**DELEGATED DECISION FOR APPLICATION FOR CERTIFICATE OF  
LAWFUL DEVELOPMENT**

Reference no.: 2026/CL/91420/W

Site: 11, Deer Croft Crescent, Salendine Nook,  
Huddersfield, HD3 3SG

Description: Certificate of lawfulness for proposed for erection  
of extension and front porch and conversion of garage to habitable  
accommodation

**Proposed Front Elevation**  
1 : 100

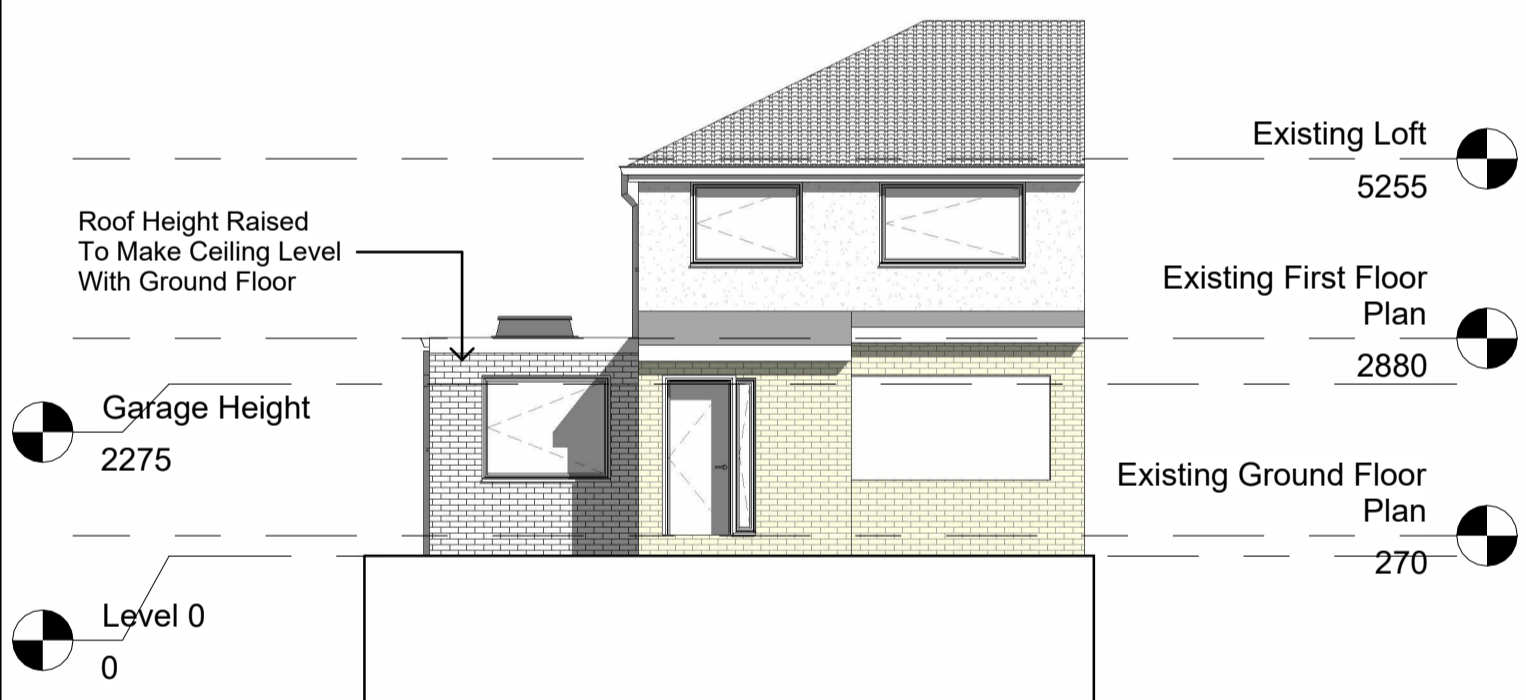
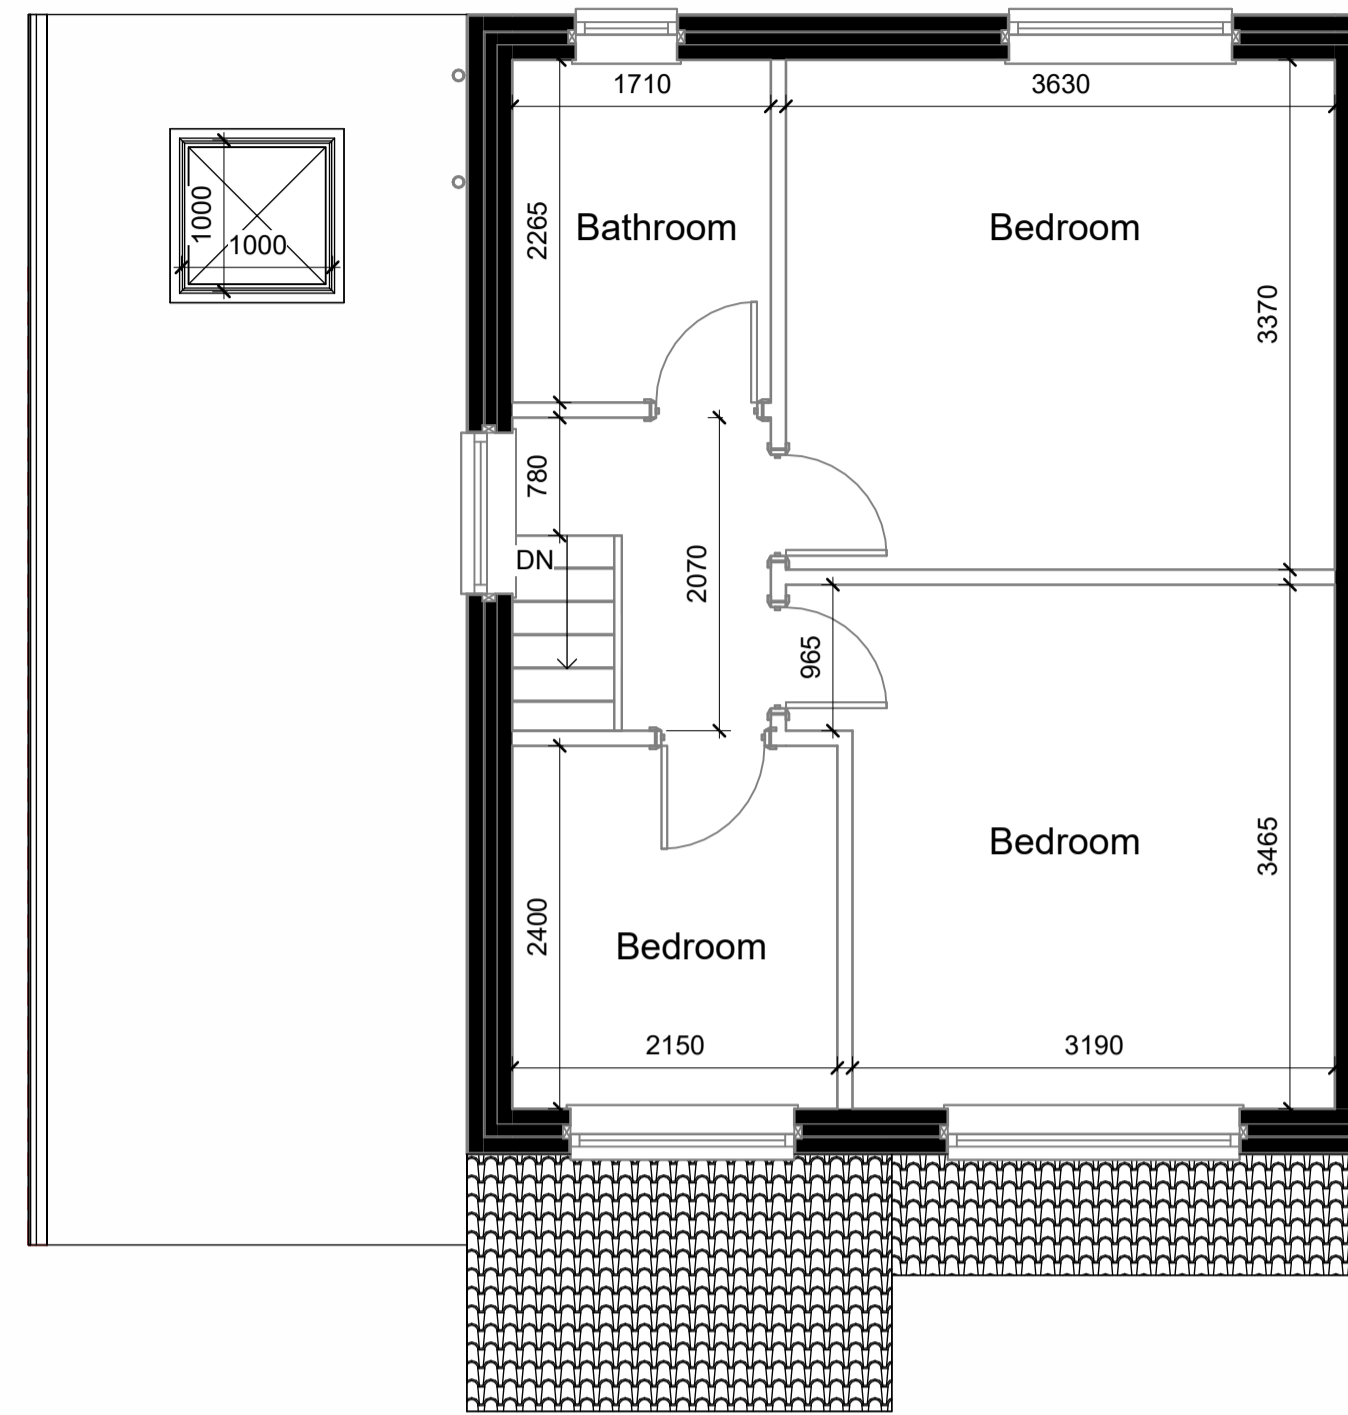
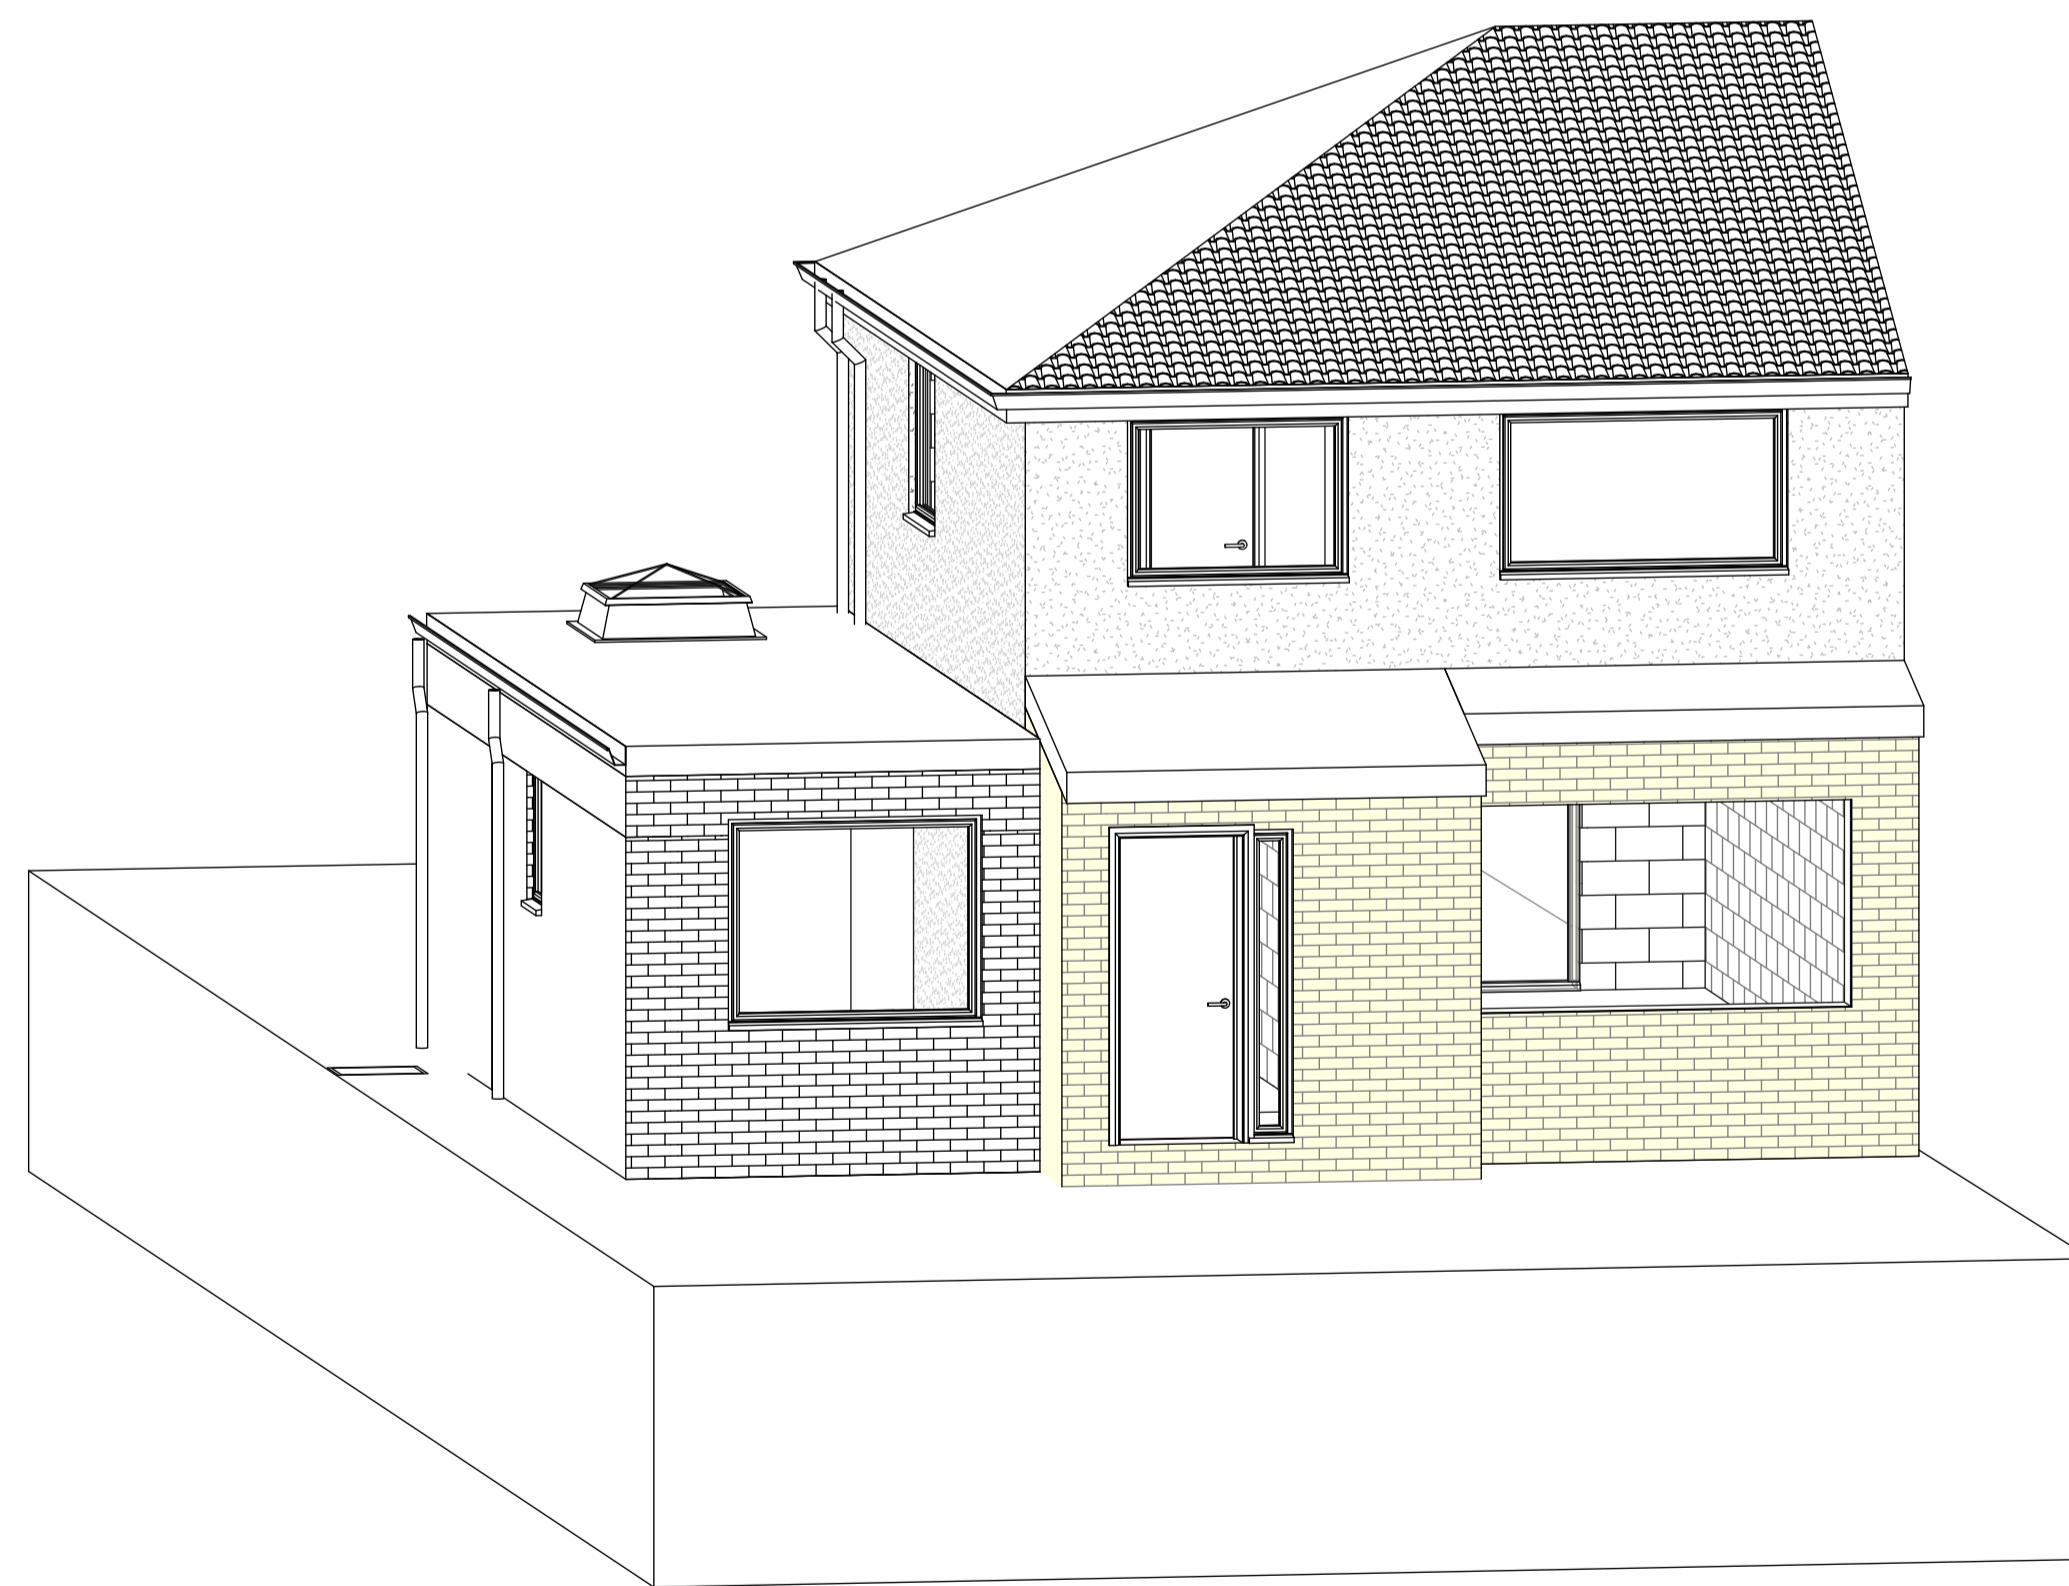
A porch is proposed to be constructed on the front elevation of the property. It would project forward of the section of front elevation by 1.5 metres and would have a width of 2.8 metres and an overall height of 3.3 metres.

***Comment:*** *The ground area of the porch would exceed 3 metres and would therefore fail to meet this requirement.*

***Comment:*** *The porch would be more than 3 metres above ground level and would therefore fail to meet this requirement.*

The proposed porch does not benefit from a general planning permission under Article 3(1) and Schedule 2, Part 1, Classes A and D of the Town and Country Planning (General Permitted Development) (England) Order 2015 (as amended) as the structure would fail to comply with paragraphs D.3(b) and (c) of the same Order.

**Proposed Ground Floor Plan**  
1 : 50

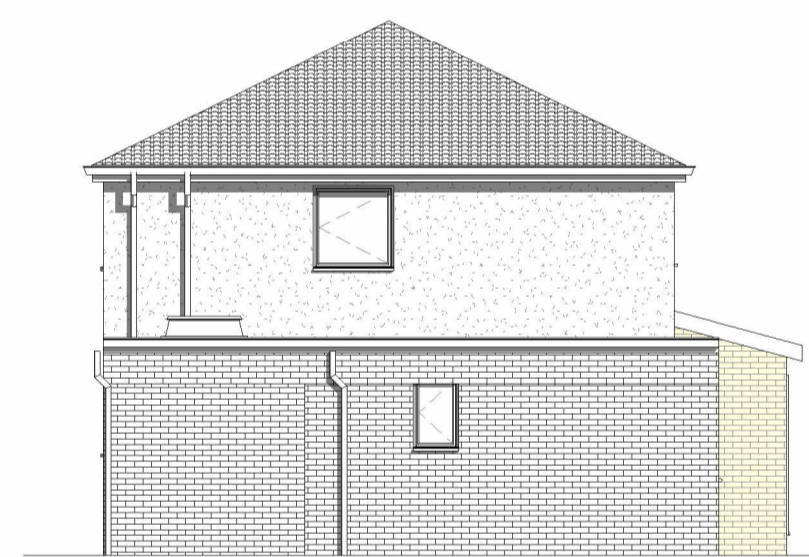
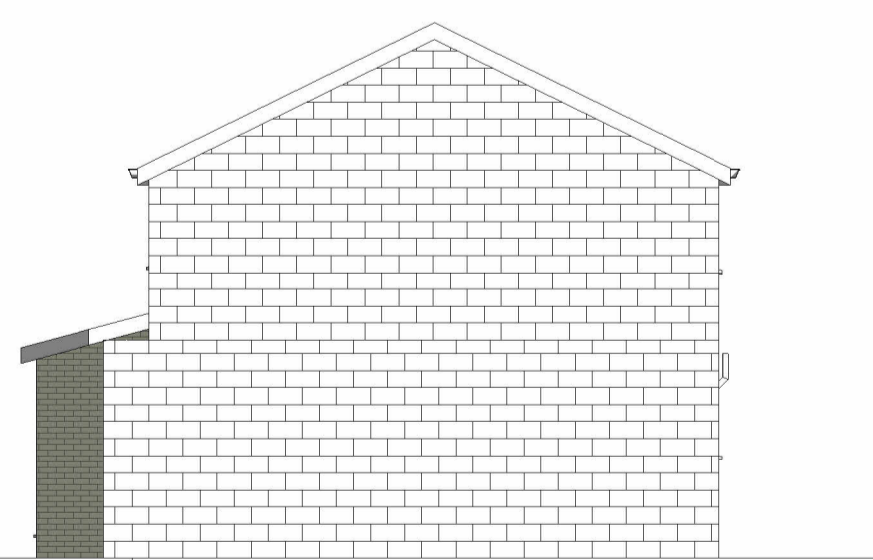
The proposed extension would lie flush with the front elevation of the property and would project to the side by 2.8 meters. The extension would span the full depth of the property lying flush with the rear elevation. The extension would have an overall height of 2.8 metres.

As concluded above, the existing garage would be extended and raised in height and is therefore considered to be a new extension. Therefore, whilst interpreting the proposed as a new extension, the conversion of the garage shall still be assessed for completeness. It is proposed that the garage door

would be removed and walled up and a window installed, the existing window within the side elevation of garage would be removed and a smaller one installed. Internally, the garage accommodation would be removed and replaced with habitable accommodation.

**Comment:** *The enlarged part of the dwellinghouse and garage conversion would be within 2 metres of the boundary of the curtilage of the dwellinghouse although the eaves (overall height in this case) would not exceed 3 metres.*

**Comment:** *The proposed extension would be to the side of the dwellinghouse however it would not exceed 4 metres in height, would not have more than a single storey and would not have a width greater than half the width of the original dwellinghouse.*

The single storey side extension/garage conversion benefits from a general planning permission granted by virtue of Article 3(1) and Schedule 2, Part 1, Class A of the Town and Country Planning (General Permitted Development) (England) Order 2015 (as amended) subject to conditions within Class A.3 of the same Order.
